Date: 27/01/2026**Project: 372-374 Mann Street & 35-37 Dwyer Street, North Gosford NSW****NSW Government ref No. SSD-69773460****Client: The Trustee for Stockbridge Property Unit Trust****RE: Response to Department of Planning, Housing and Infrastructure RFI letter (Dated 27 November 2025) – Engineering matters**

We are writing in response to the civil/stormwater management-related items mentioned in the RFI letter.

Sheet Name:
**STORMWATER
DRAINAGE SECTIONS
AND DETAILS SHEET 3**

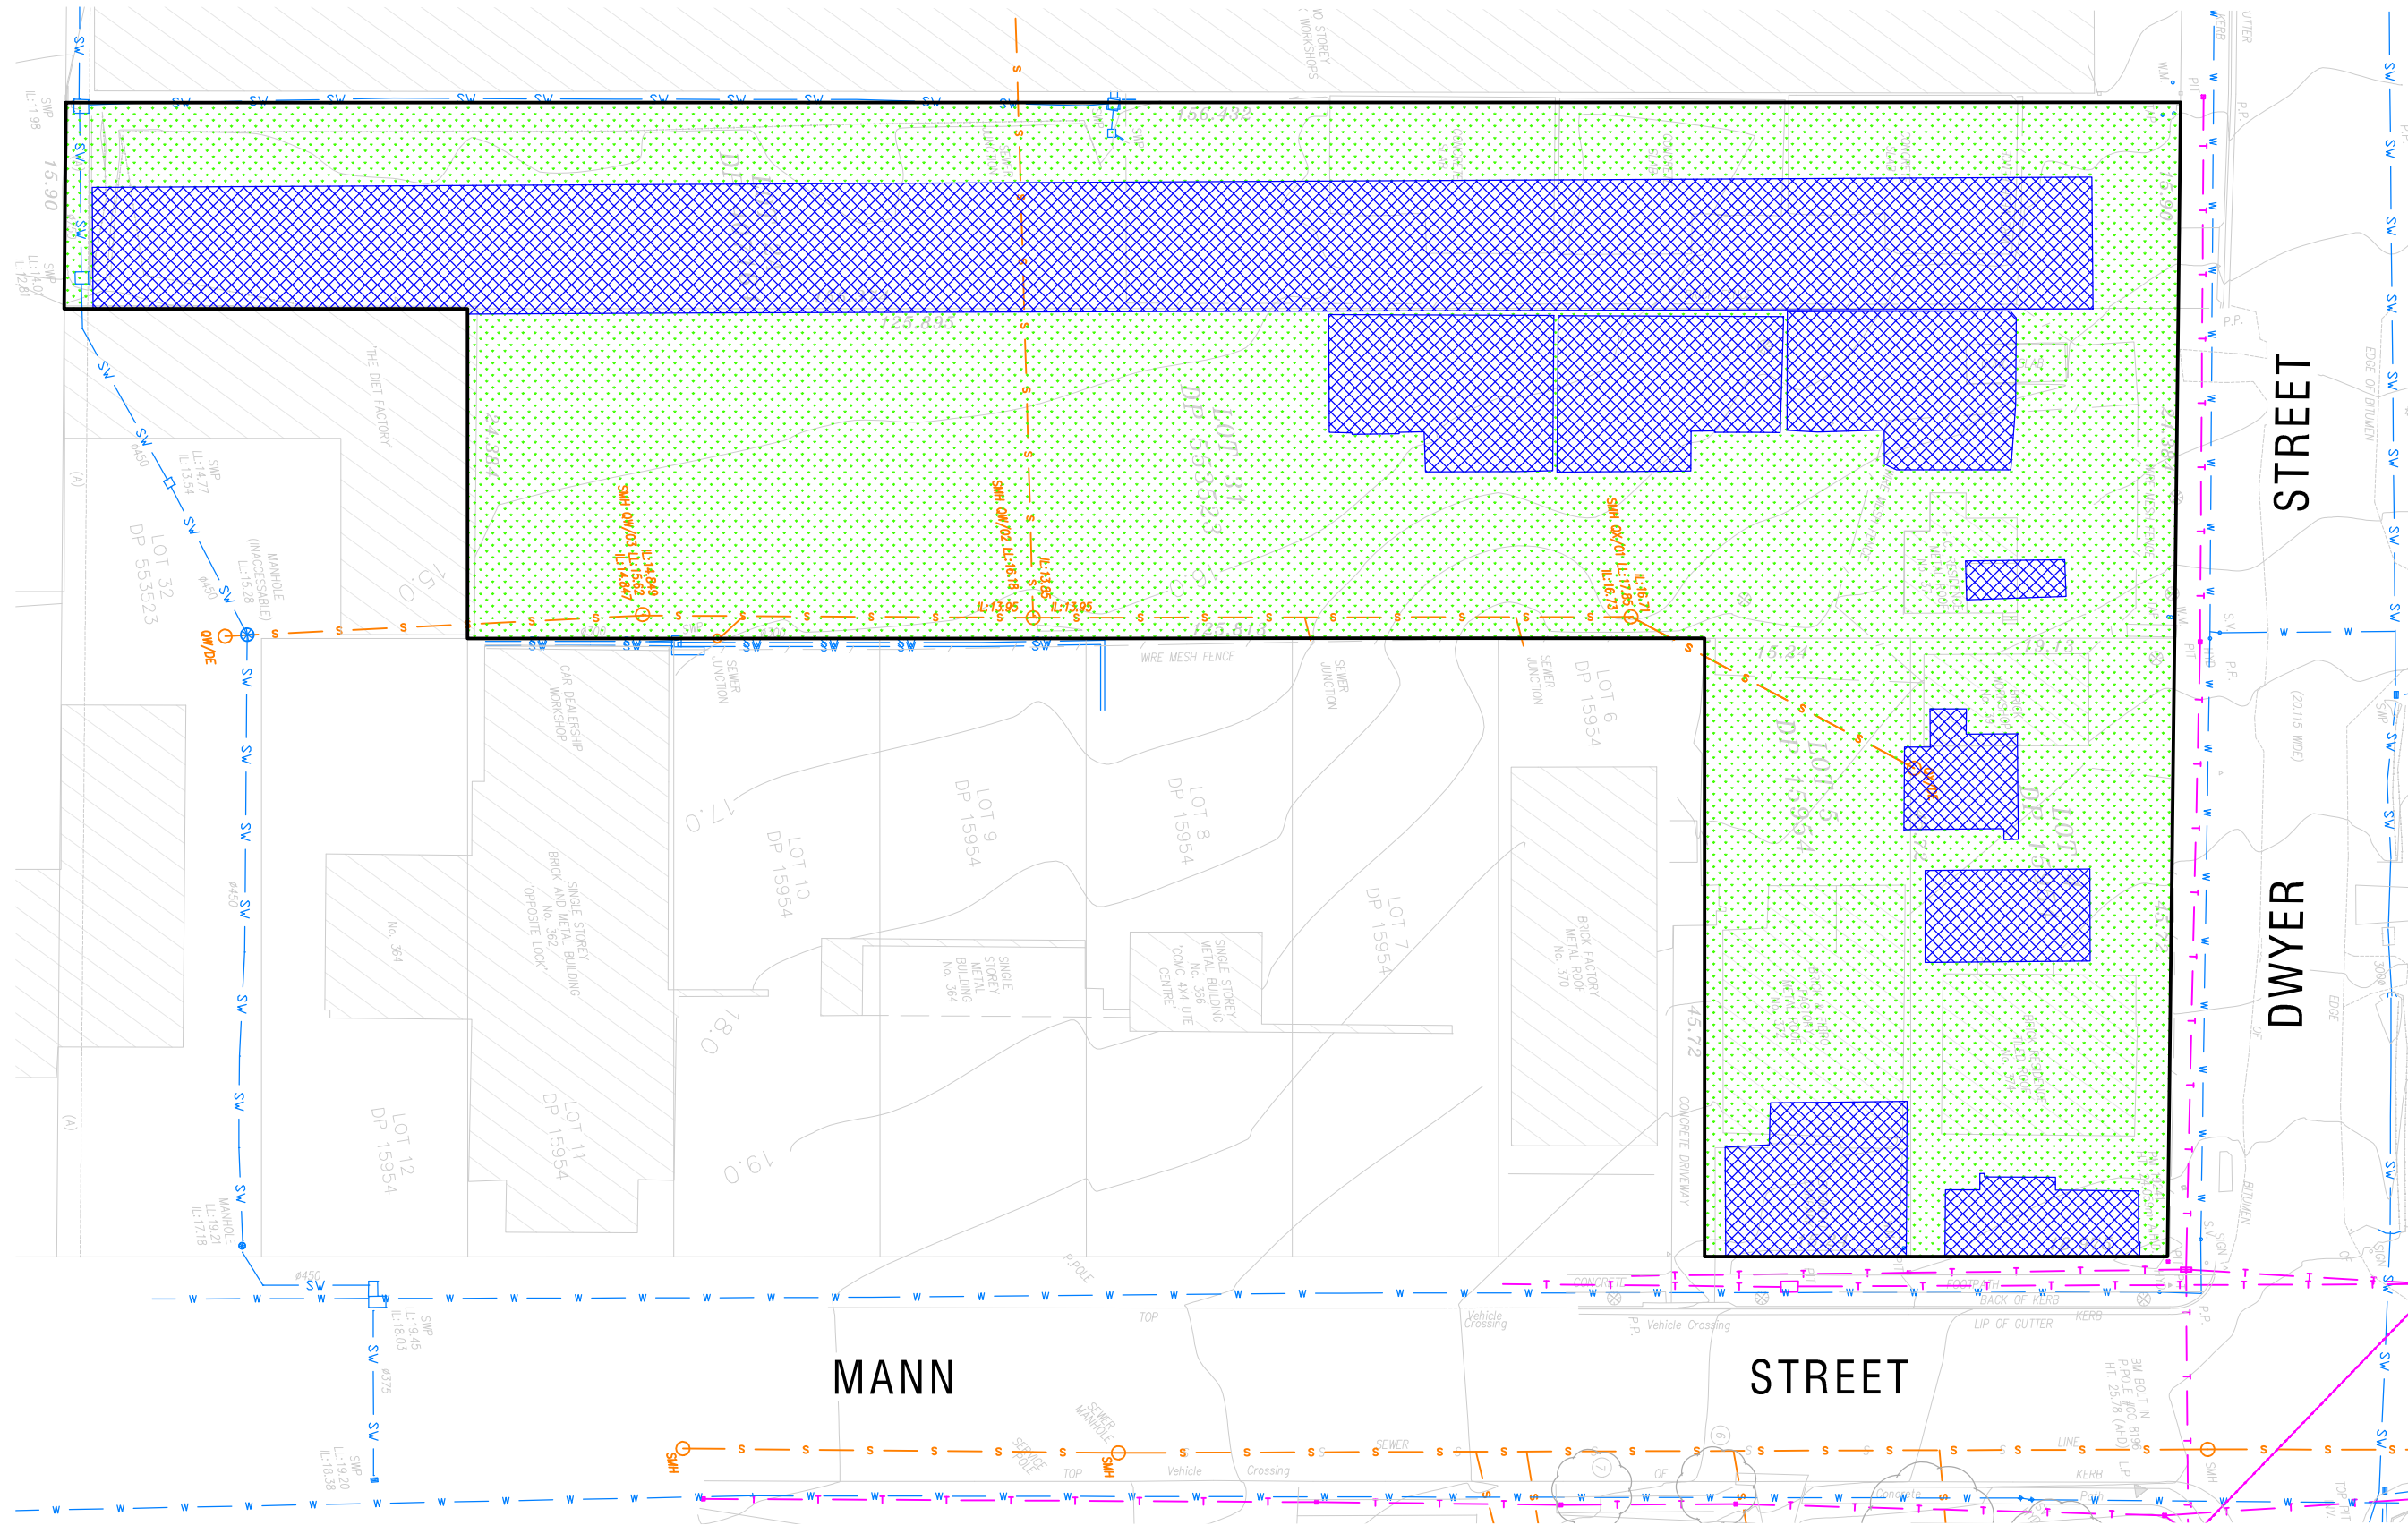
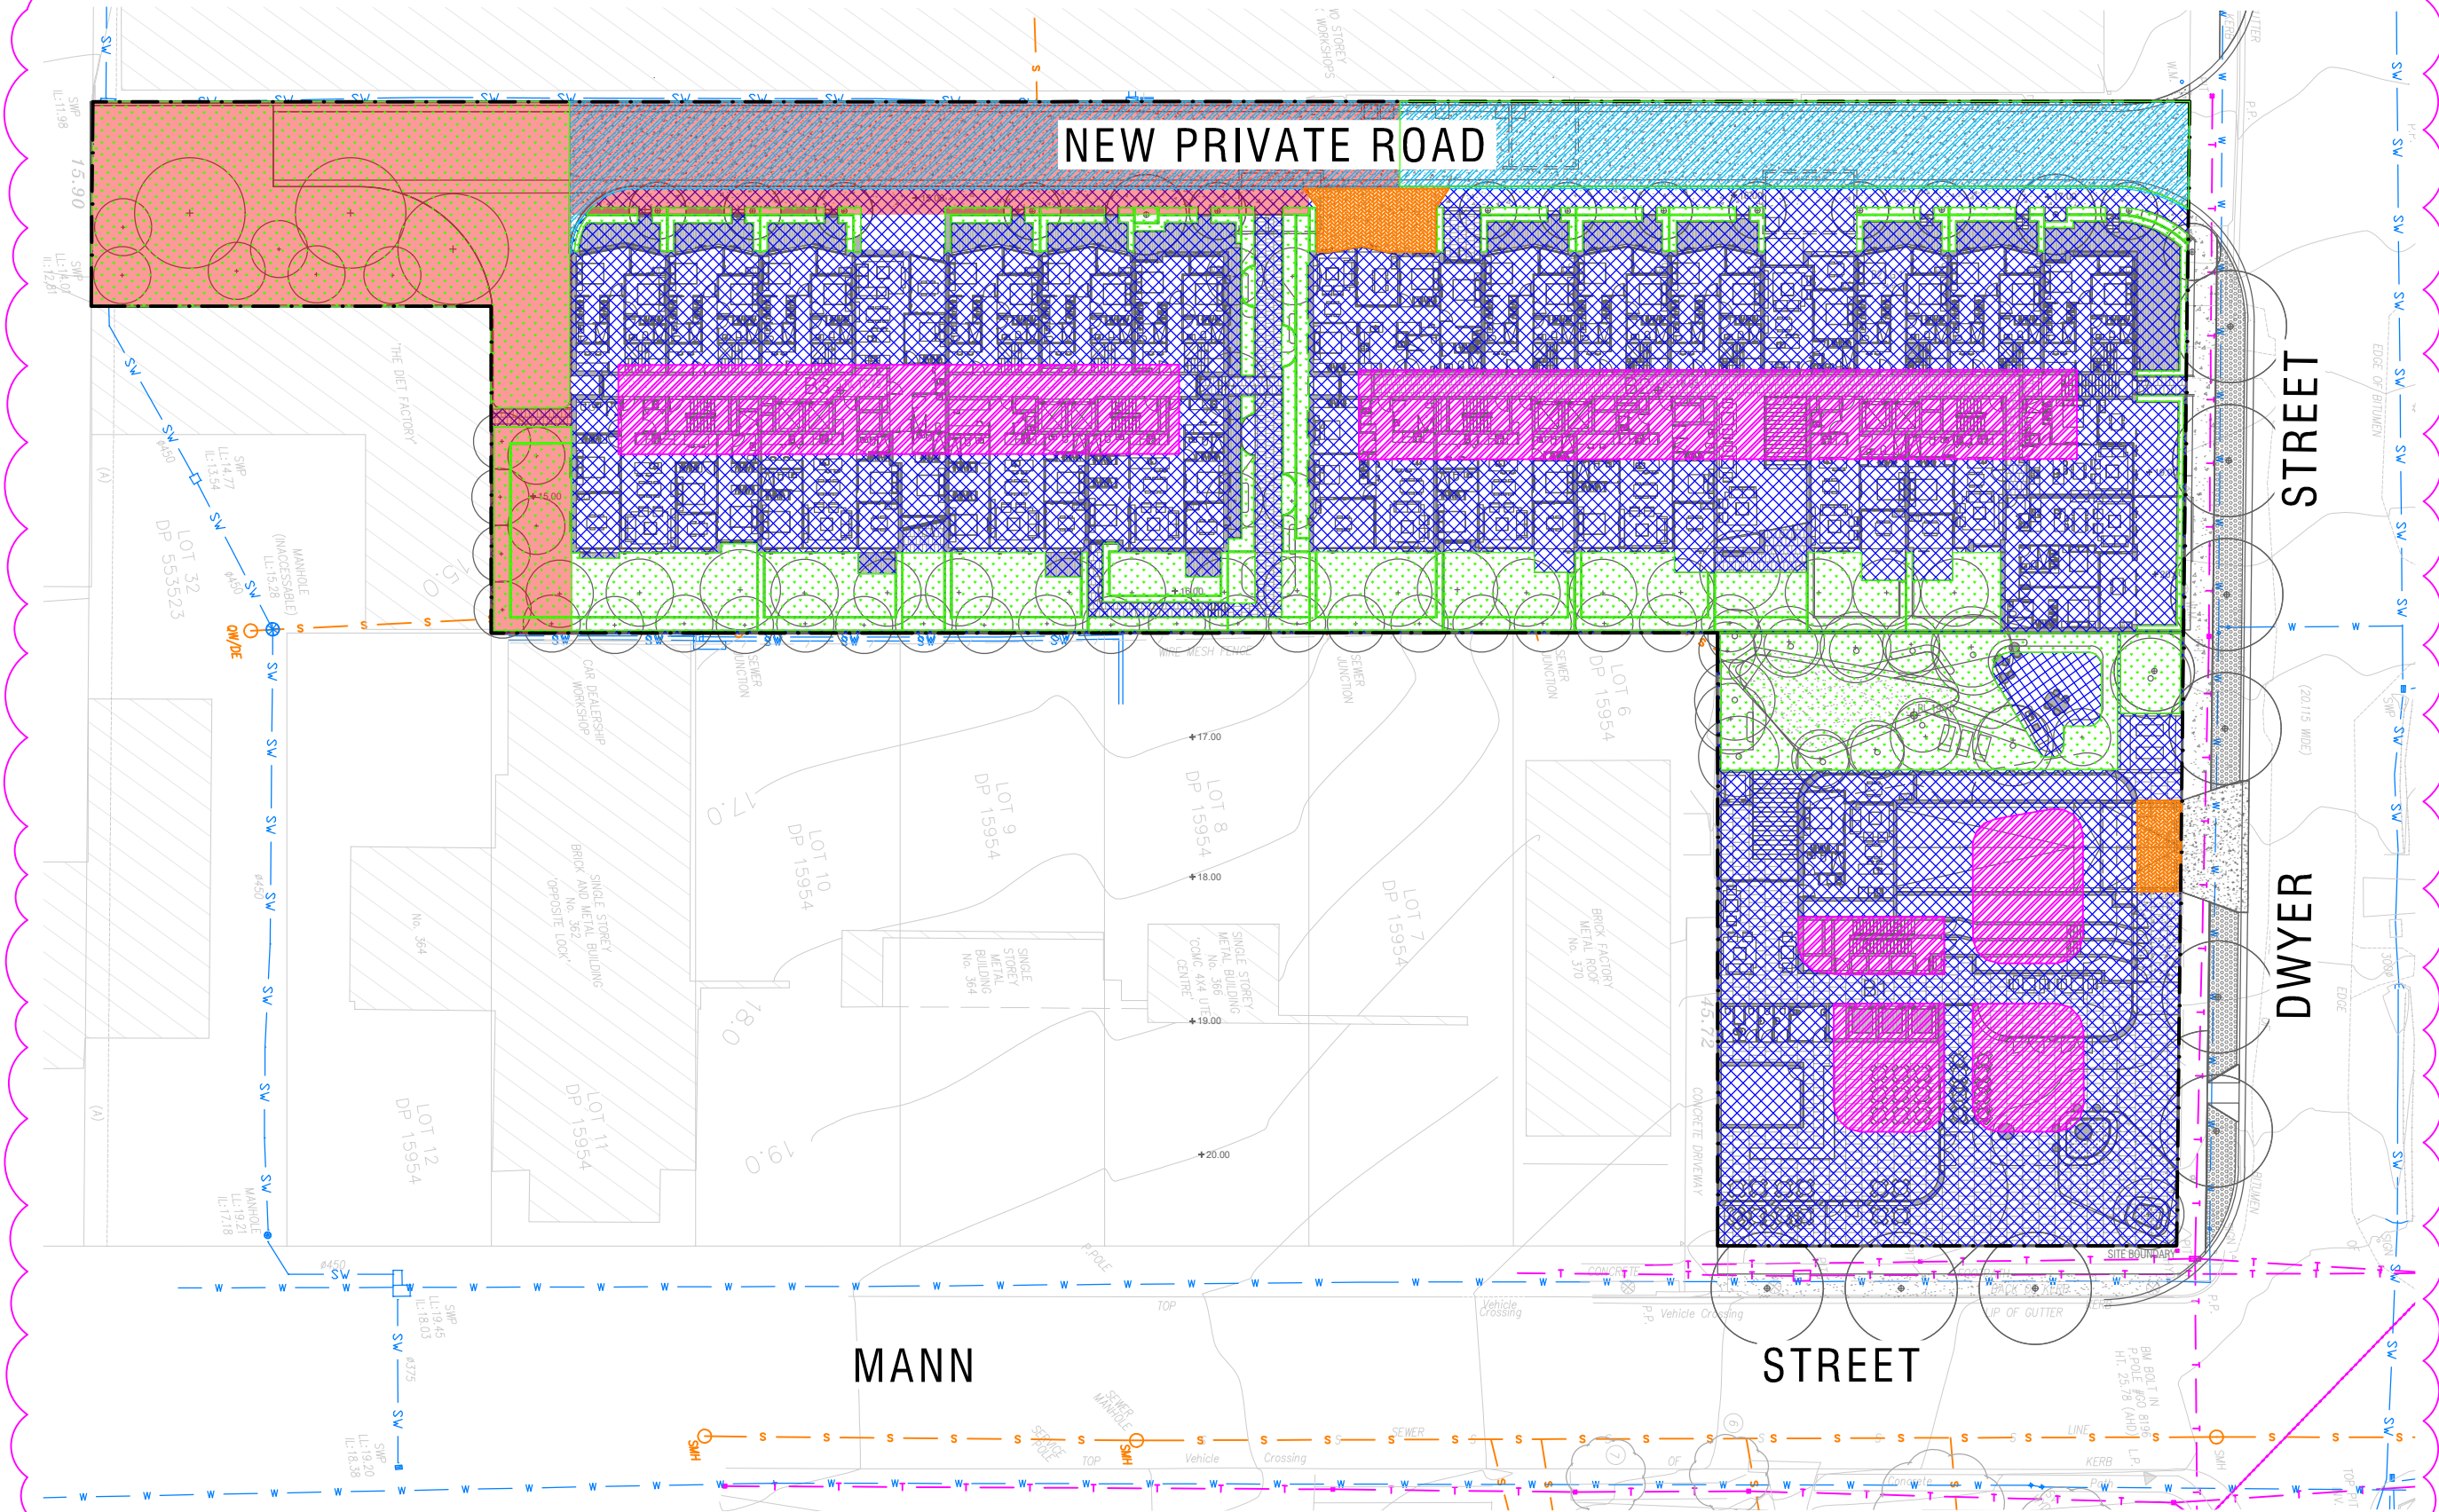
- *RFI #5 – providing information that demonstrates how the existing 450mm diameter Council stormwater pipeline that the development proposes to connect to has the capacity to accept additional stormwater flows from the development.*

Response: As set out in Section 5, and in particular Section 5.2, of the Civil Engineering Report prepared by this office, the inclusion of the proposed on-site detention (OSD) system ensures that post-development stormwater flows are reduced to pre-development levels. This has been demonstrated in both the stormwater plans and the accompanying engineering report. Accordingly, no additional flows will be discharged into the existing 450 mm diameter downstream pipe.

Furthermore, based on the DRAINS hydrological modelling, with the inclusion of the OSD system, the post-development peak flow for the 1% AEP storm event is reduced to 0.332 m³/s compared to the pre-development peak flow of 0.384 m³/s. Similarly, for the 5% AEP storm event, the post-development peak flow is reduced to 0.239 m³/s from a pre-development peak flow of 0.243 m³/s.

The hydraulic modelling demonstrates that under post-development conditions, peak flow rates are reduced relative to existing conditions. Accordingly, the proposed development will not result in any additional flow loadings to the existing downstream drainage network.
